File Number: D07-12-21-0180

June 14, 2022

Re: Site Plan Control Application

91 Holland Avenue

**2ND FLOOR PLAN**

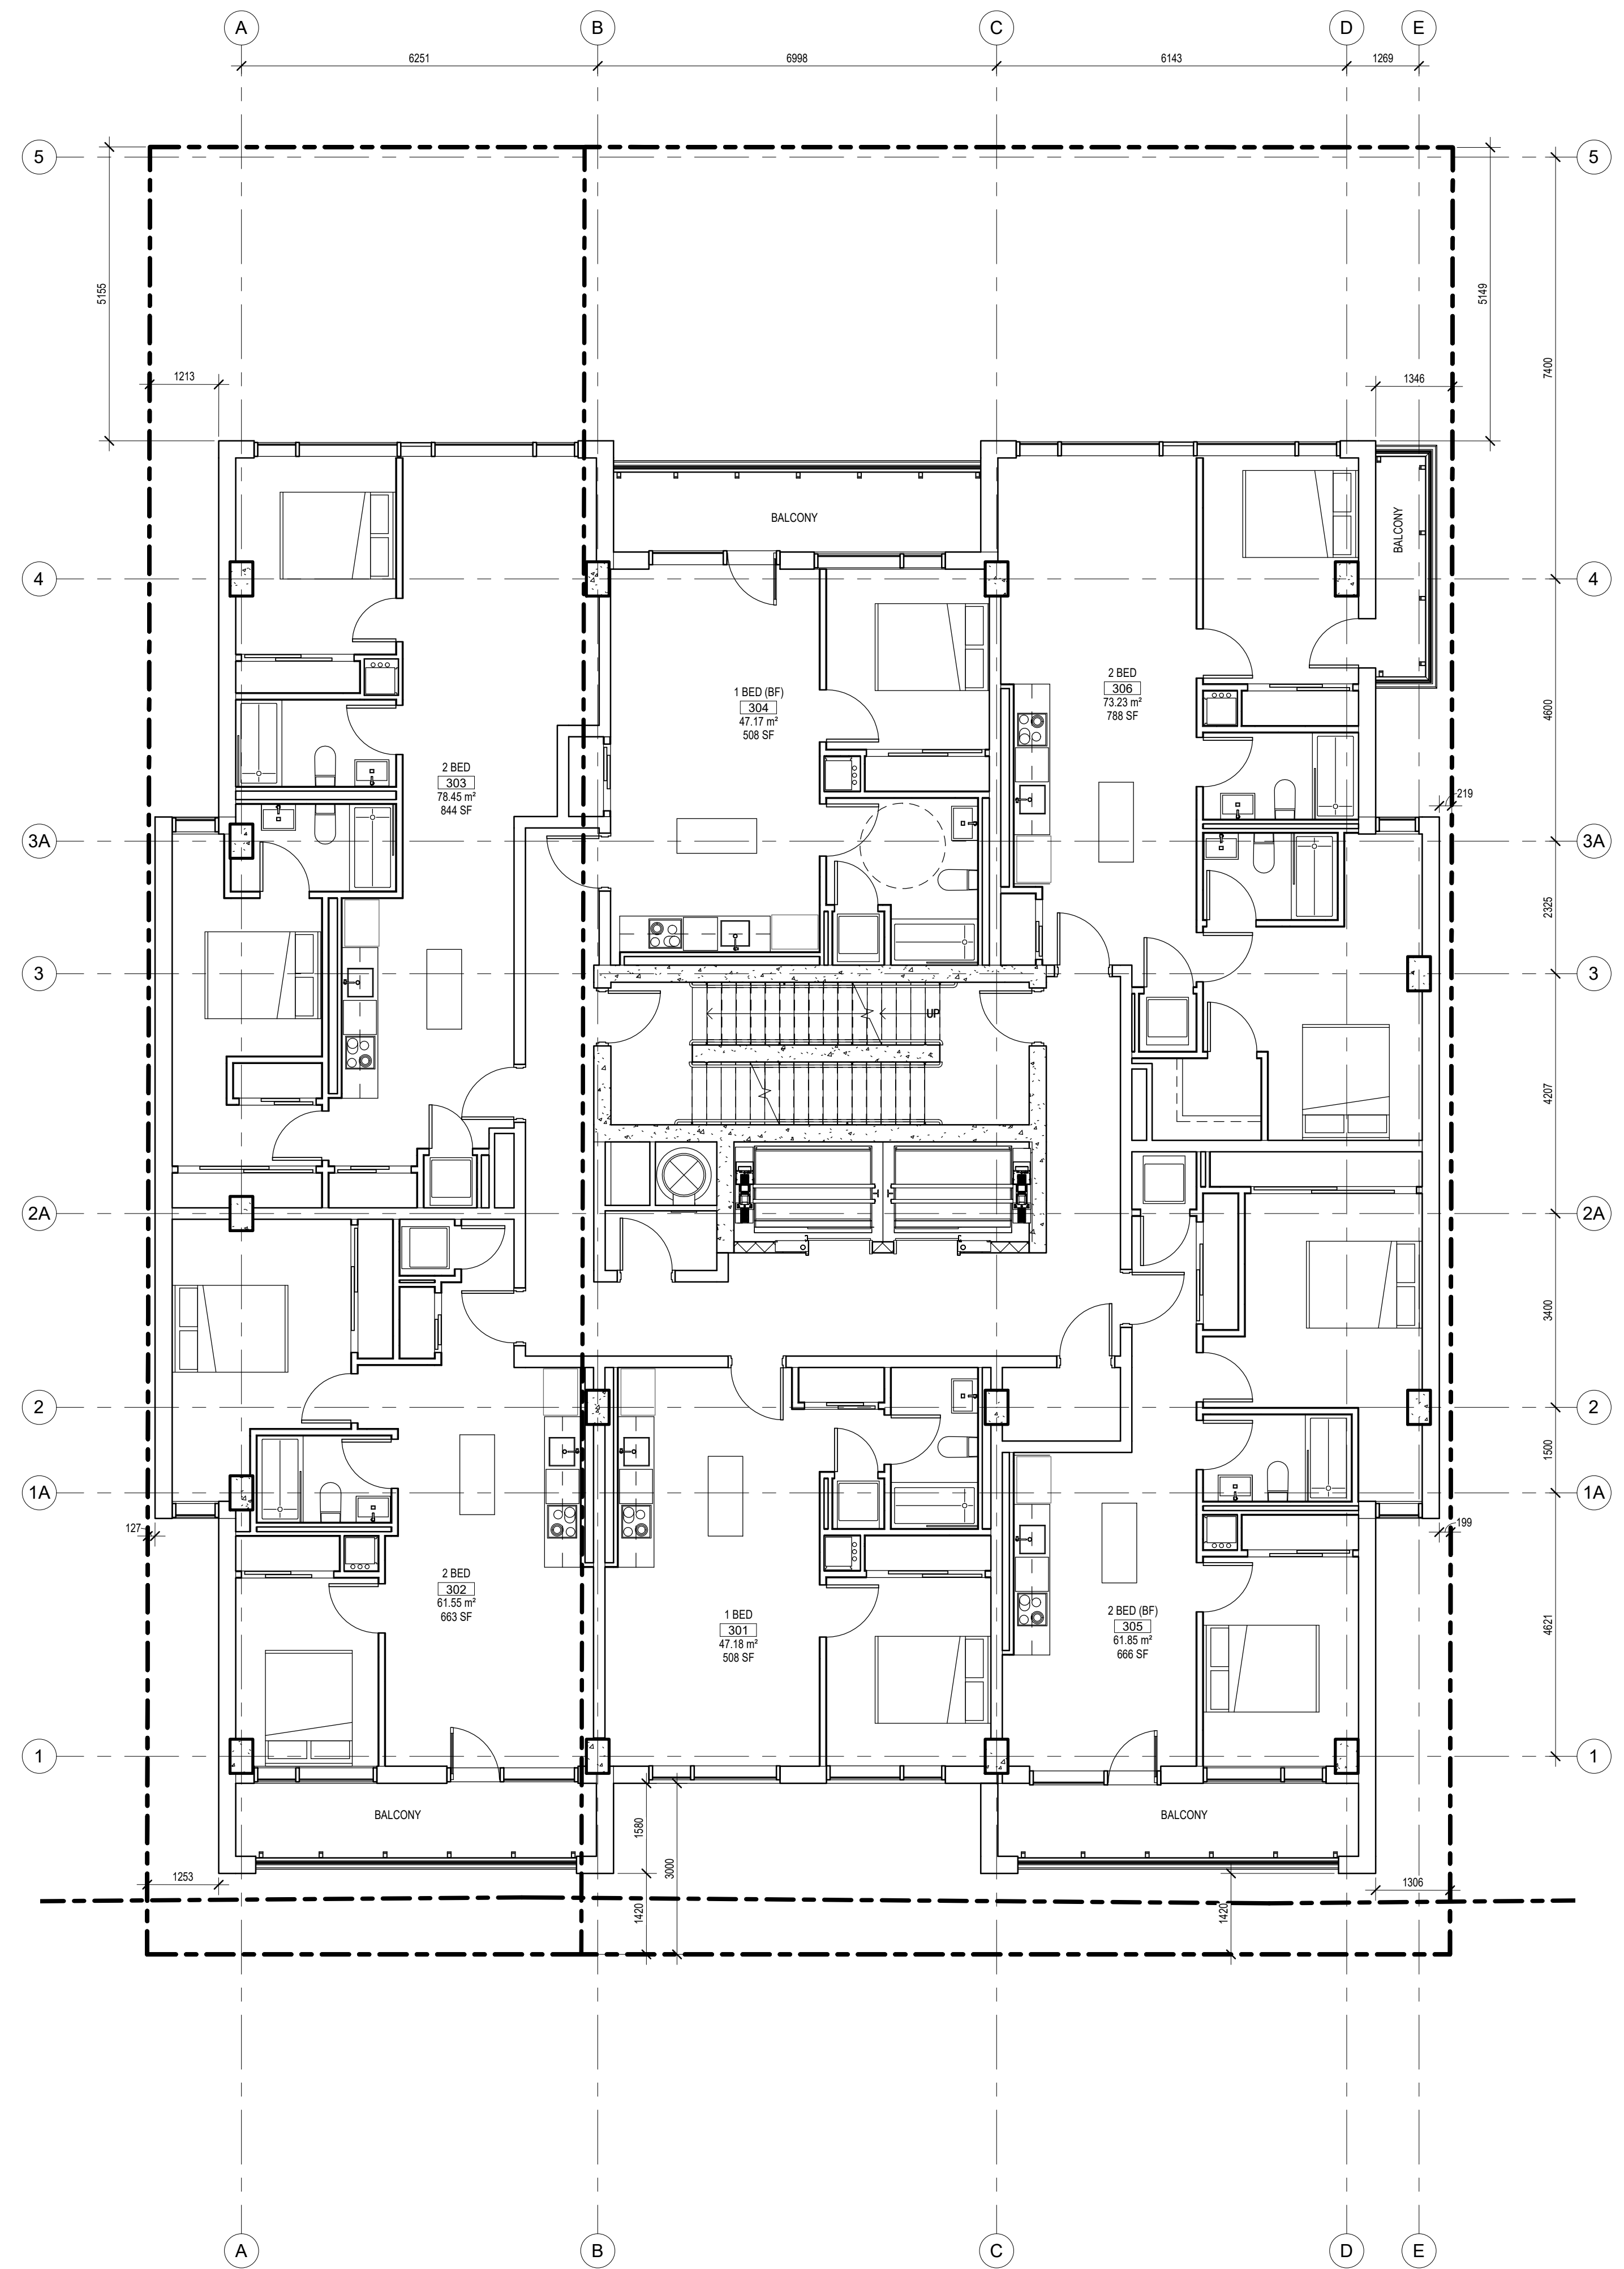
3. I appreciate the removal of balconies of units 203 and 303.
4. I continue to have concerns on the balconies of units 206 and 306 (previously 305) and their relationships with the abutting apartment building. Please provided detailed analysis of the relationships of these balconies with the abutting apartment buildings, including (not not limited to) plan view relationship, elevation relationship, and 3-d relationship.

.2 LANDSCAPE PLAN

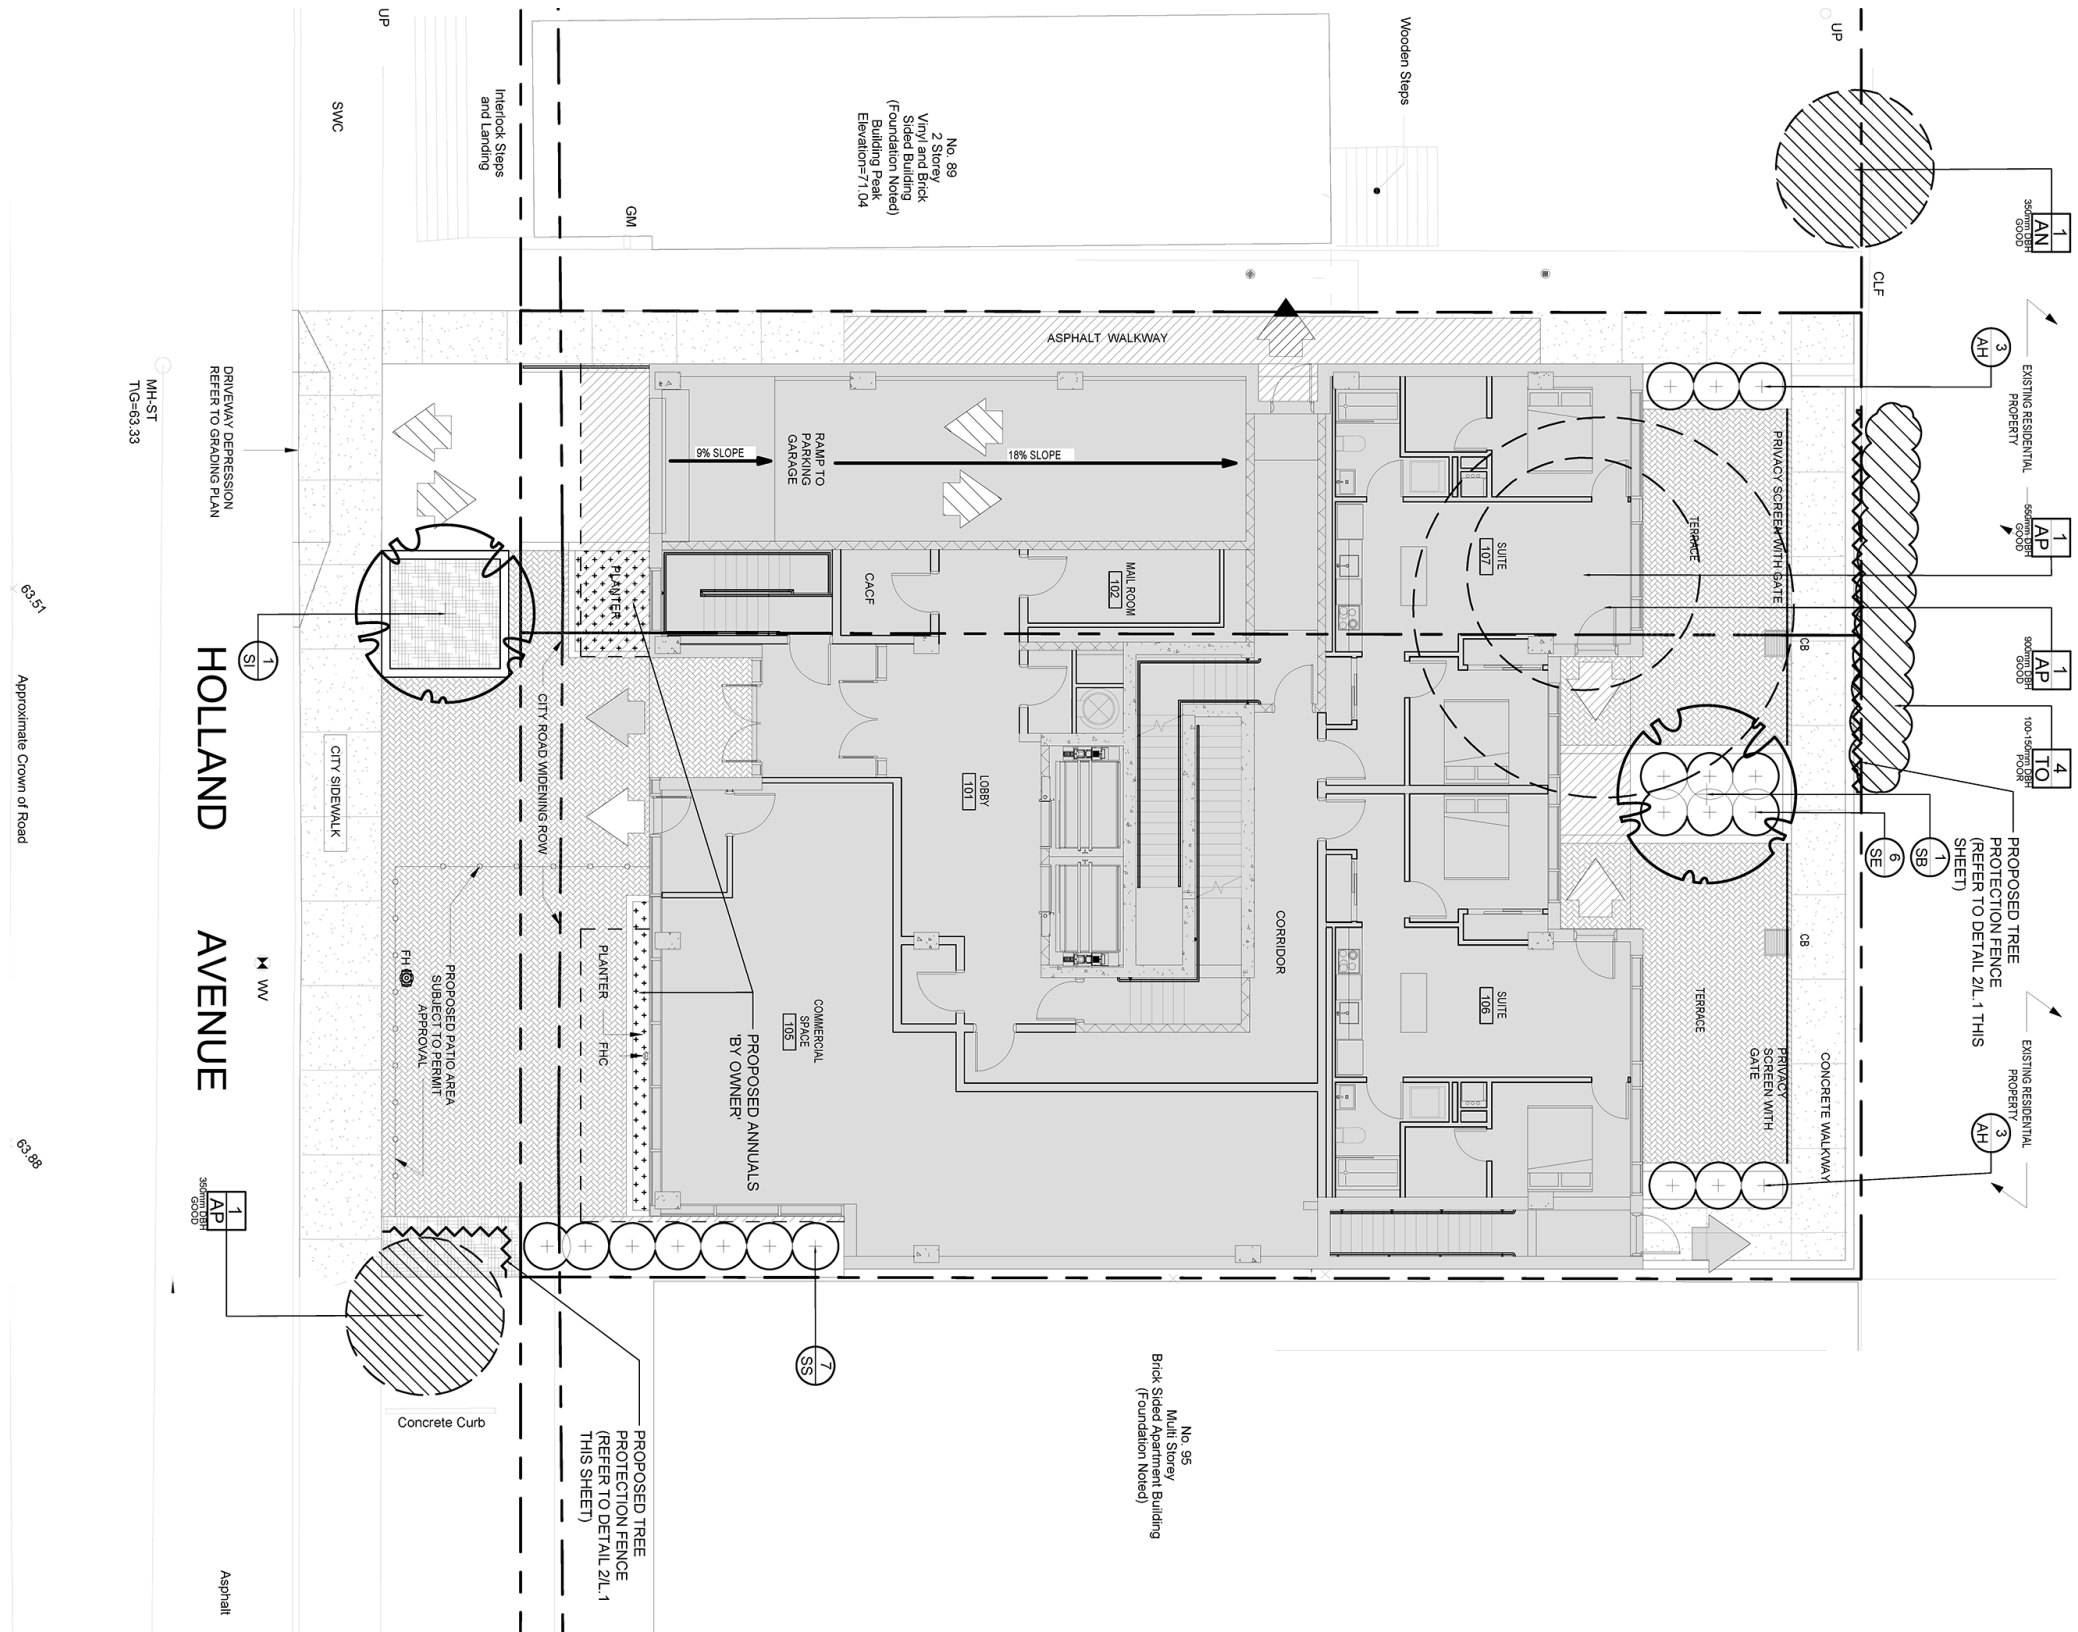
6. Please find ways to include more softscaping in the front yard. Perhaps a low planting bed next to the garage entrance. Please provide landscape plan with this.

15. Street keeper locusts have a projected height of 45' and canopy spread of 20'. Therefore this should be considered a medium sized tree species. This narrow species appears more suitable for the rear yard planting. Please replace the front

yard locust with a larger tree species. A silver maple or bur oak may be suitable species for the challenging environment.

16. The planting pit for the front yard tree is a serious concern for soil volume. The planting pit appears to be 2mx2m, which would only provide 6 cubic meters of soil. If the front entrance must be so heavily hardscaped, soil cells will be required to provide a sufficient growing environment (25-30 cubic meters) for the street tree. Otherwise reducing the hardscaping to include additional soil volume for the tree will be required.
